**Matt Duigan**  
**Swale Borough Council**  
Swale House  
East Street  
Sittingbourne  
Kent  
ME10 3HT

**Application No:** 22/505852/SUB

**Location:** Land Off Staple Street Hernhill Kent ME13 9HY

**Proposal:** Submission of Details Pursuant to condition 14 (Surface Water Drainage Scheme) of Application 20/503666/FULL.

Drawing Number: **65204882-SWE-ZZ-XX-DR-C-0100**

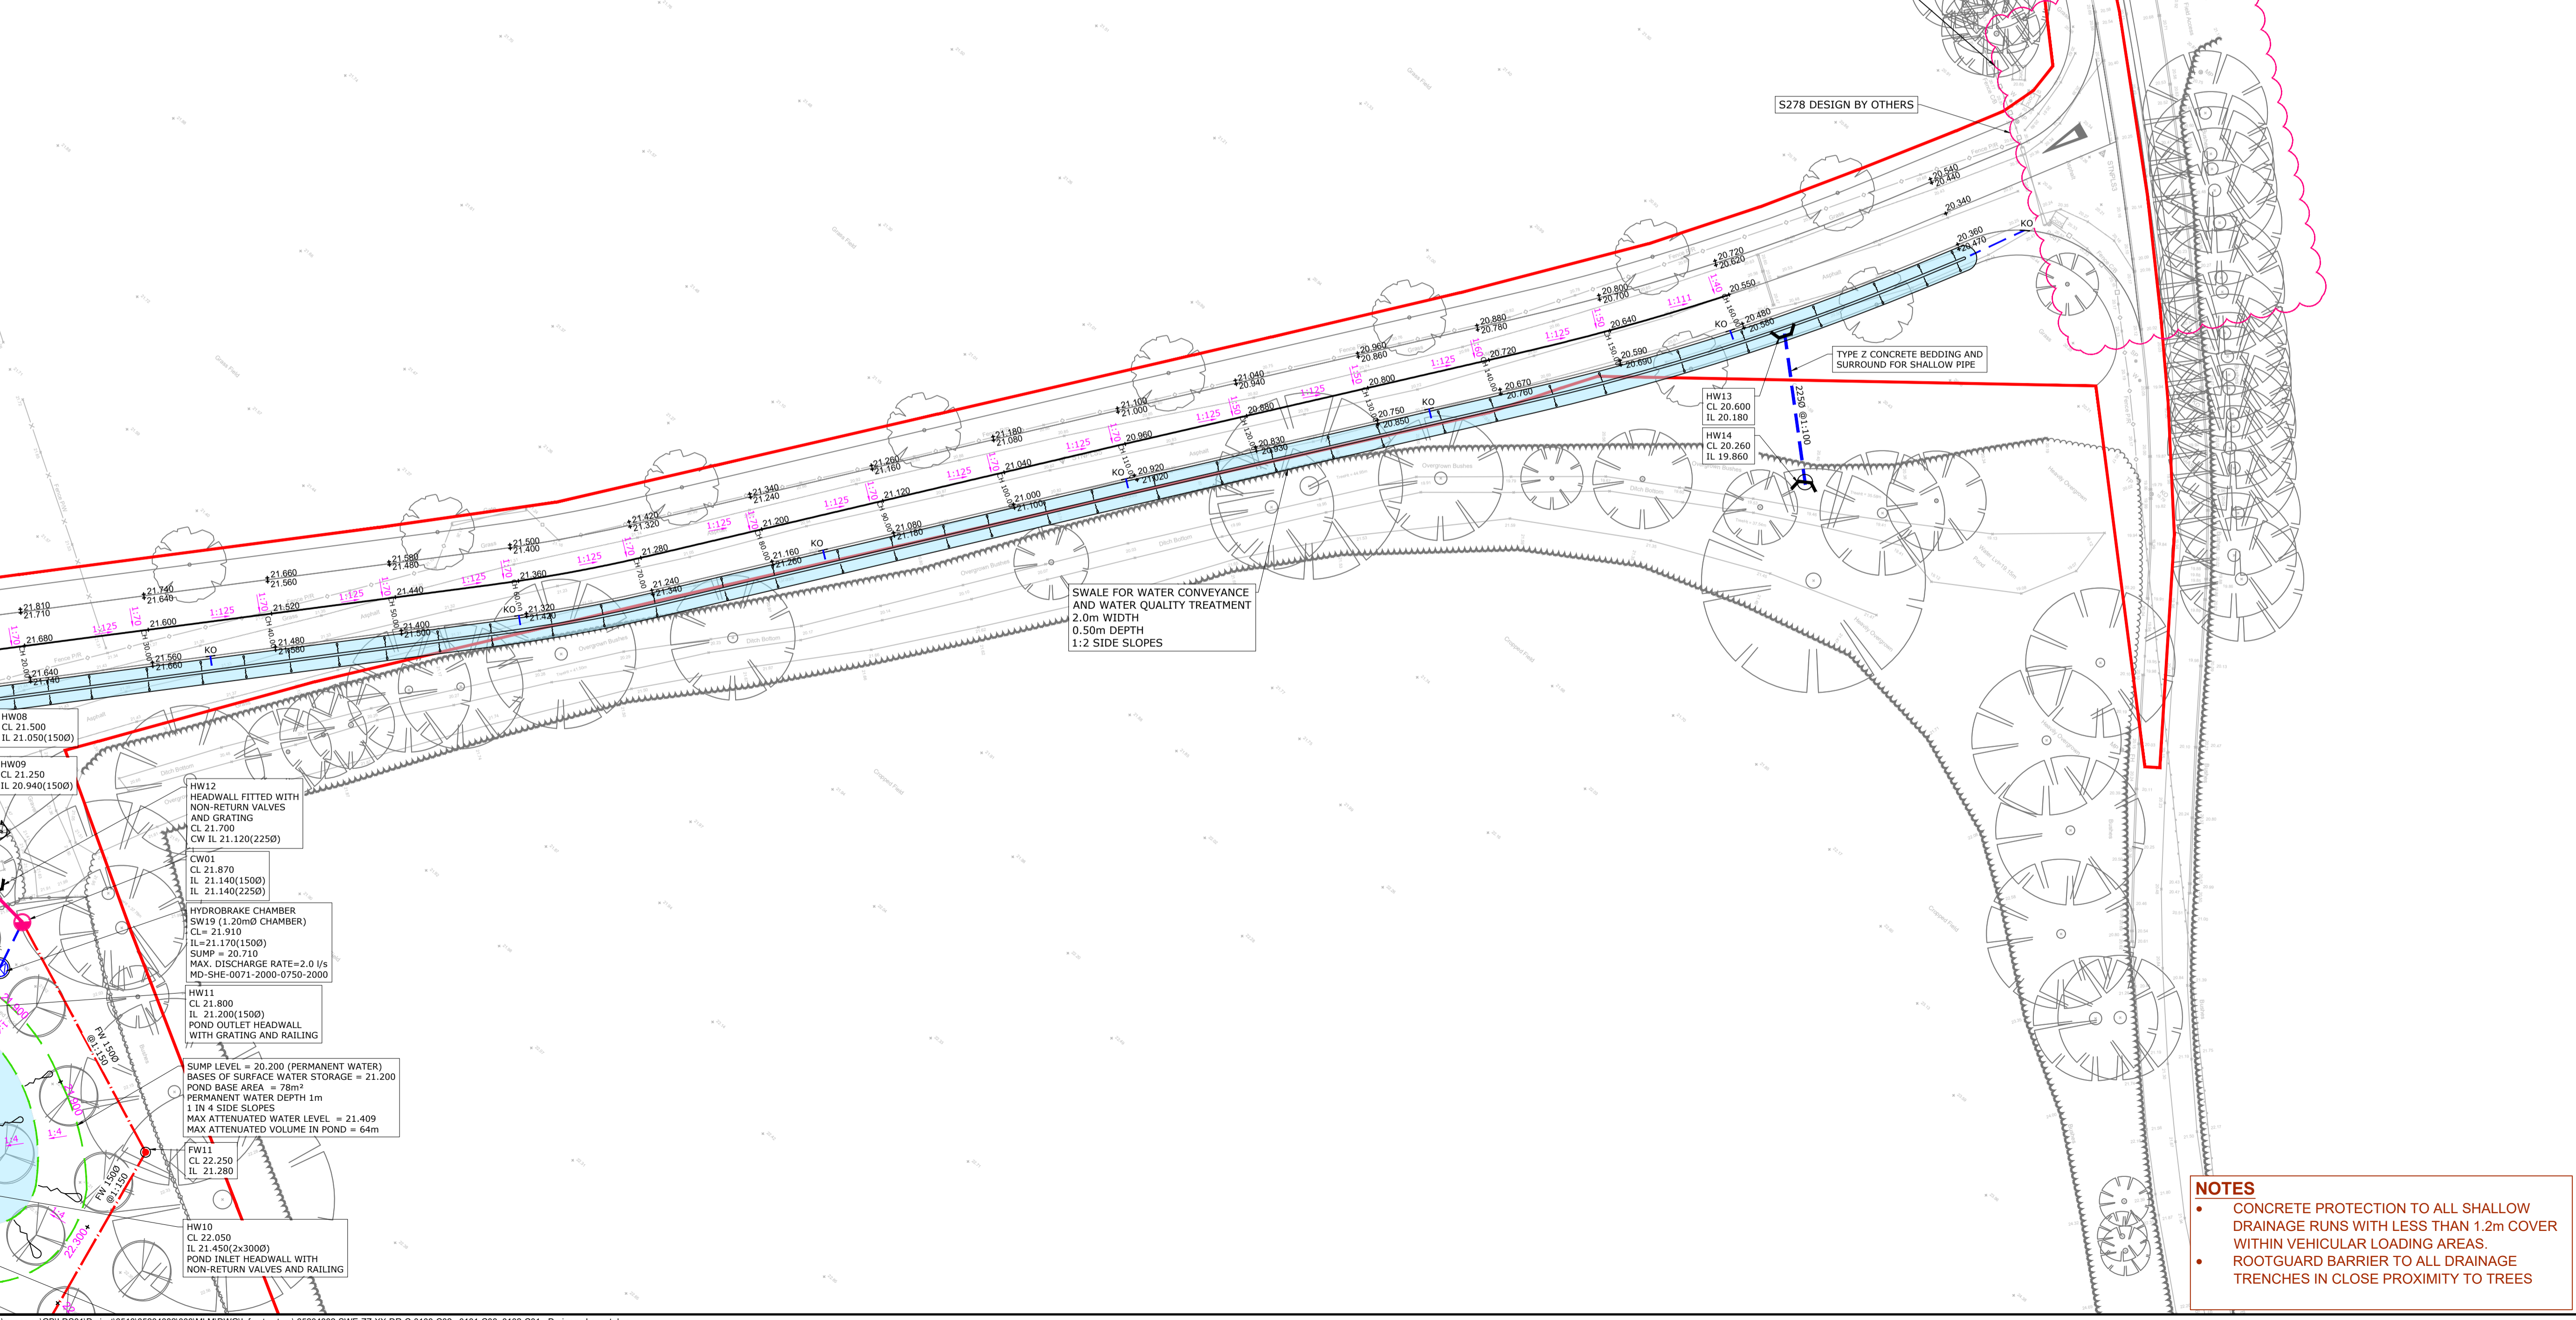
- Outputs should also contain the pipe/manhole schedule to illustrate the design modelled through the simulations (the identification of pipes and manholes in the calculations should be reflected on the accompanying drainage layout drawings).
